RULE 17 REQUEST FOR INFORMATION

19TH JUNE 2025

ERYC RESPONSES

Title:
Tourism Assets within the Direct Assessment Area

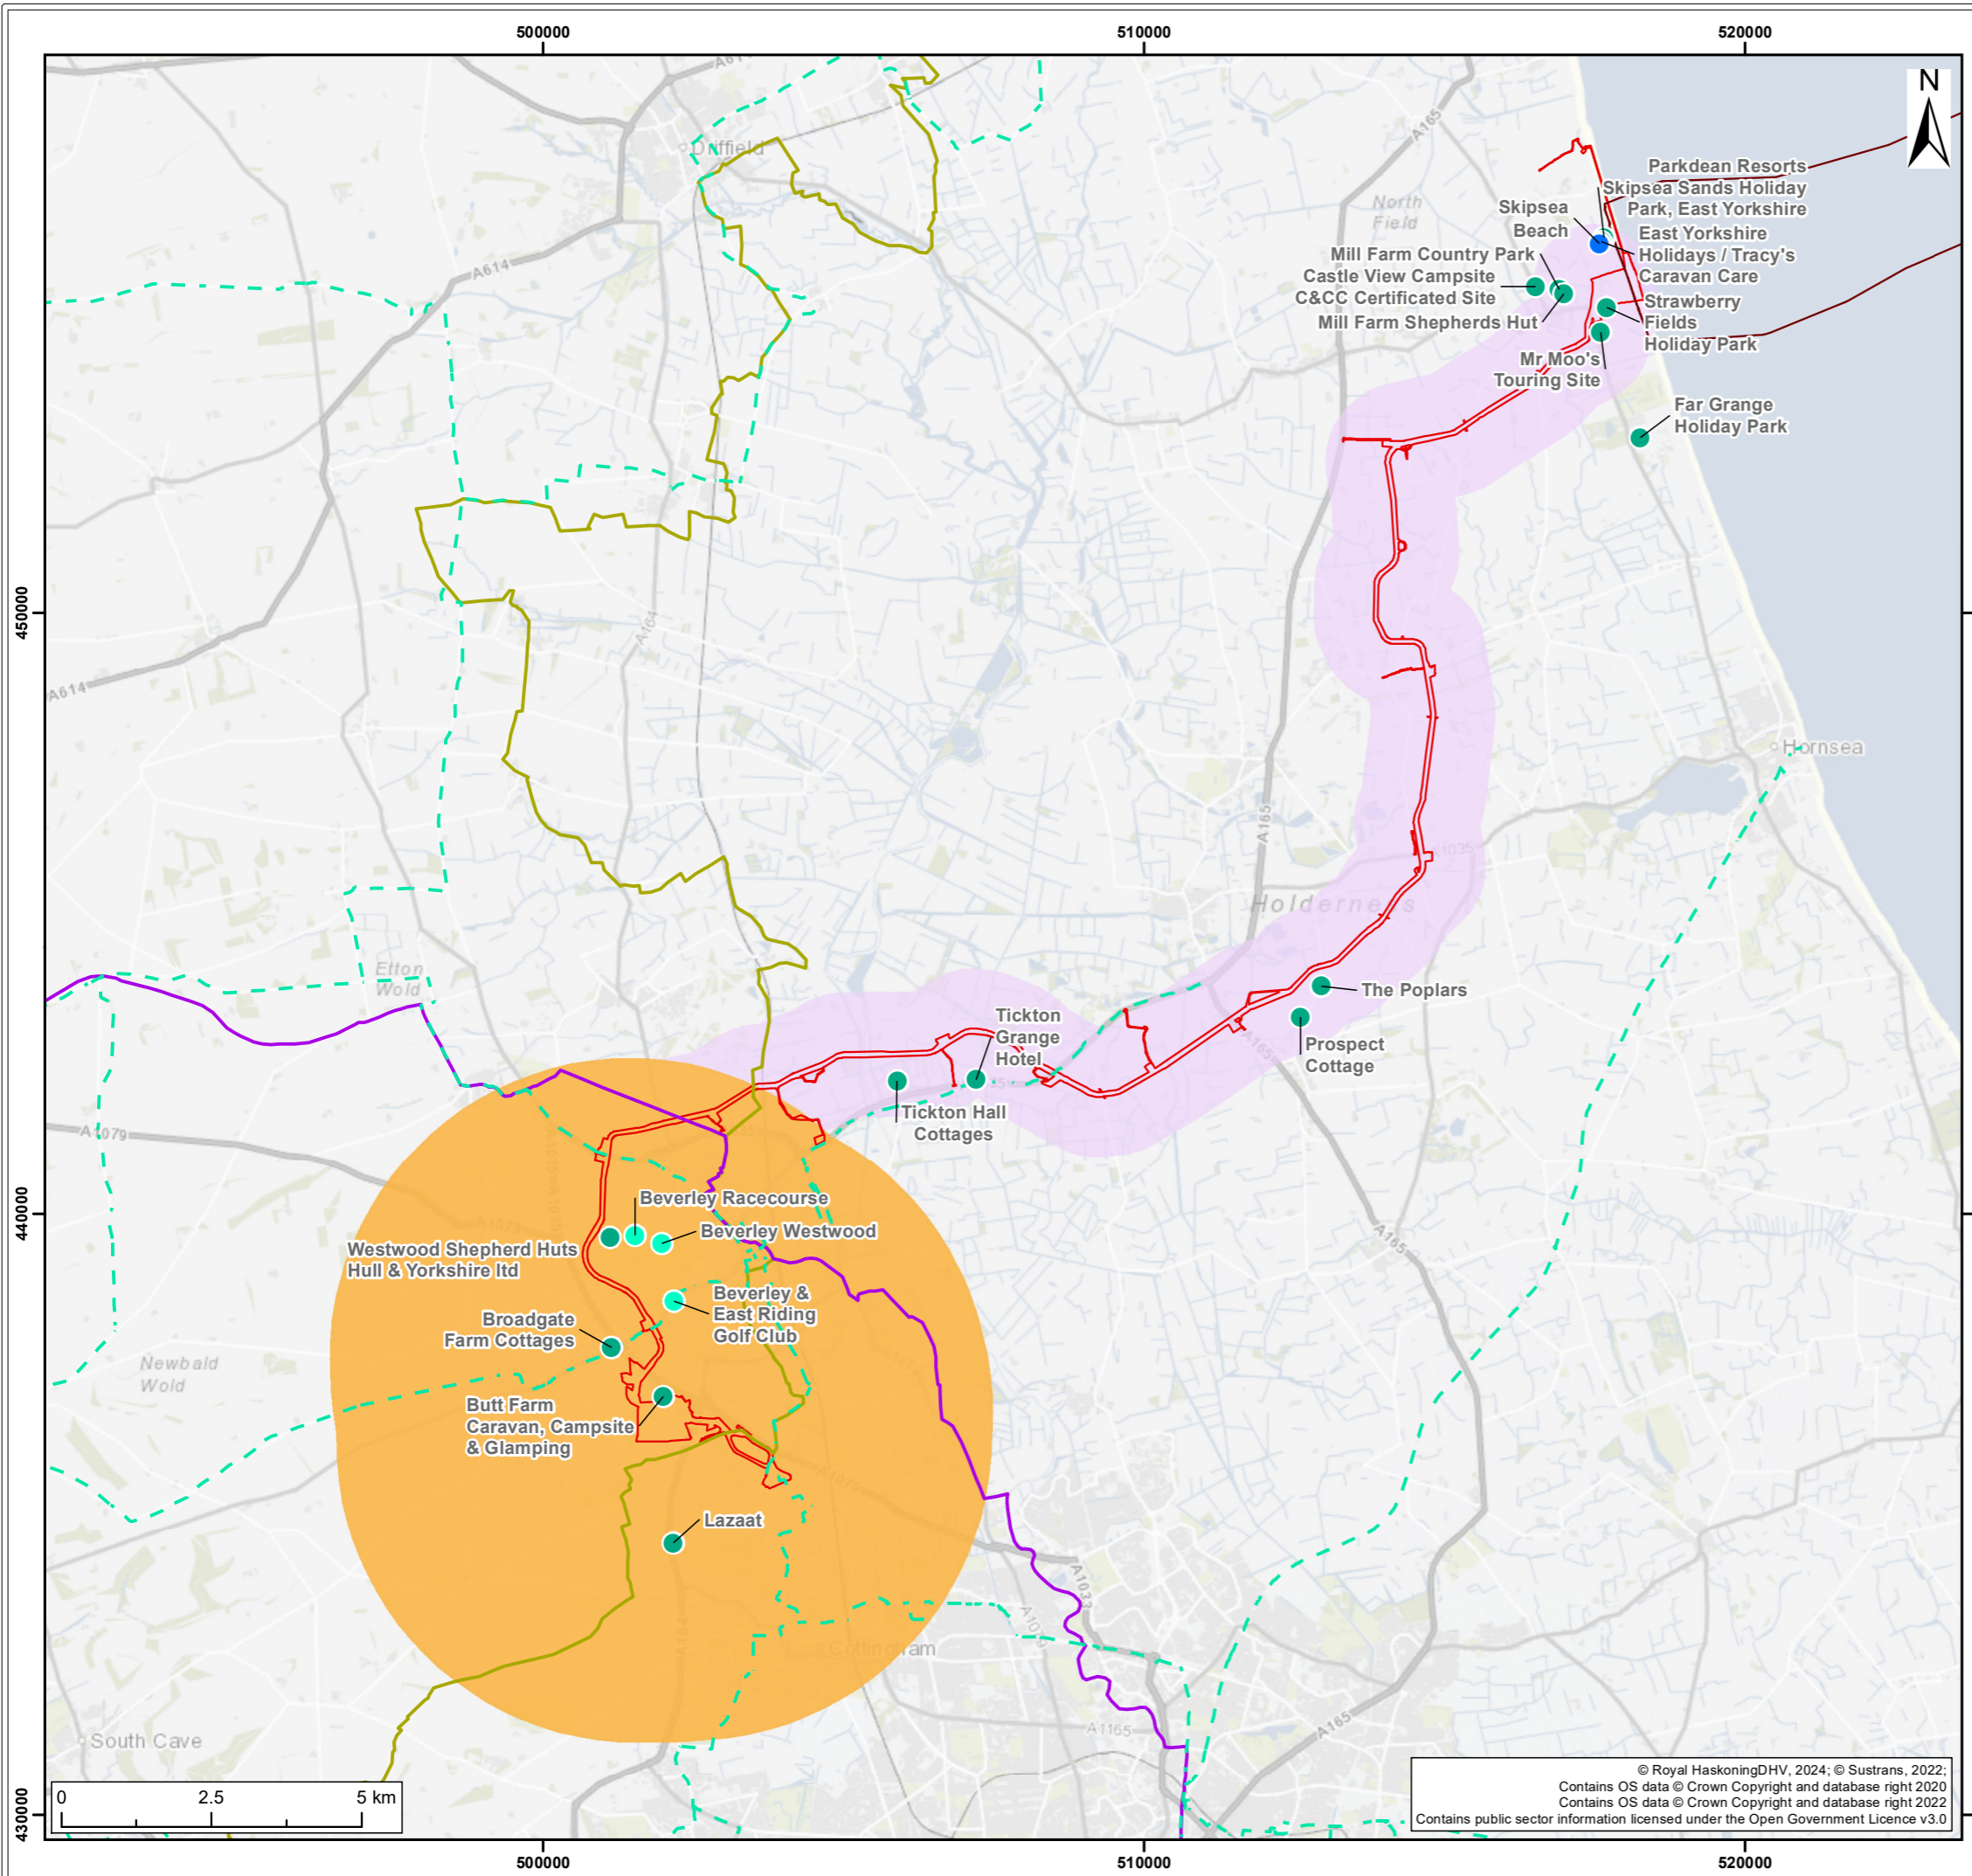
We agree with the updated significance of effects assessment for tourism assets (Impact 2) with particular regard to the change of landscape and visual impacts during operation for Butt Farm Caravans, Campsite and Glamping and the additional consideration of noise impacts during construction for Butt Farm Caravans, Campsite and Glamping and Strawberry Fields Holiday Park. However the businesses operating models are individual to them. Small businesses are very sensitive to change so what might be deemed a minor issue from an external perspective could actually have a very detrimental effect . Therefore careful consideration should be given to any extraordinary impact that the business might identify / encounter as a result of the construction and ongoing operation of the development. It would be advisable to review all mitigation proposals and work closely with the business to provide the best solution possible.
